1 LANDSCAPE PLAN
L1.0 SCALE: 1" = 10'-0"

COMCAST
MONUMENT
SERVICE UPGRADE
20021 BEACON LITE ROAD
MONUMENT, COLORADO

LANDSCAPE PLAN
 SCALE: 1" = 10'-0"

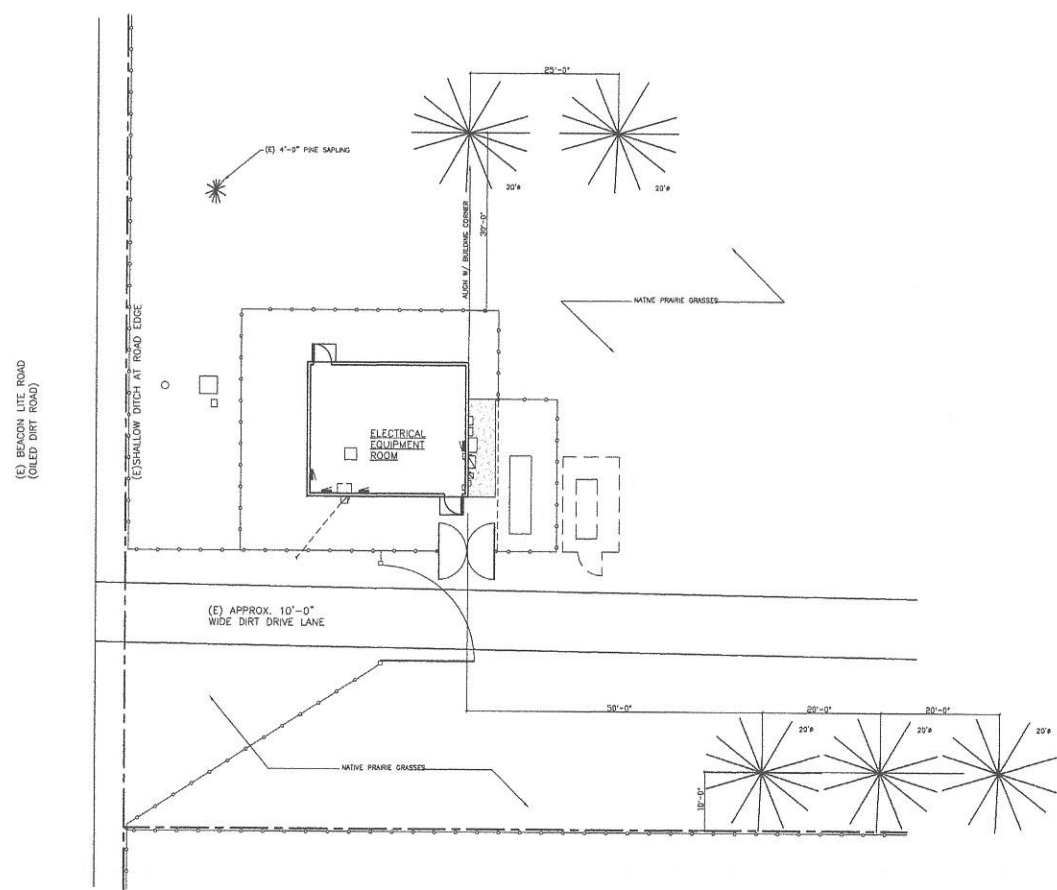
Please see Section 6.2.2 of the Land Development Code for the Landscaping Requirements. This site does not meet the landscape requirements. Please revise the plan accordingly. If an alternative plan is proposed you will need to outline the request and justification in the Letter of Intent. The Director will then approve/deny the request. Should the request be denied, the landscape plan will need to be revised to meet all the requirements listed in 6.2.2.
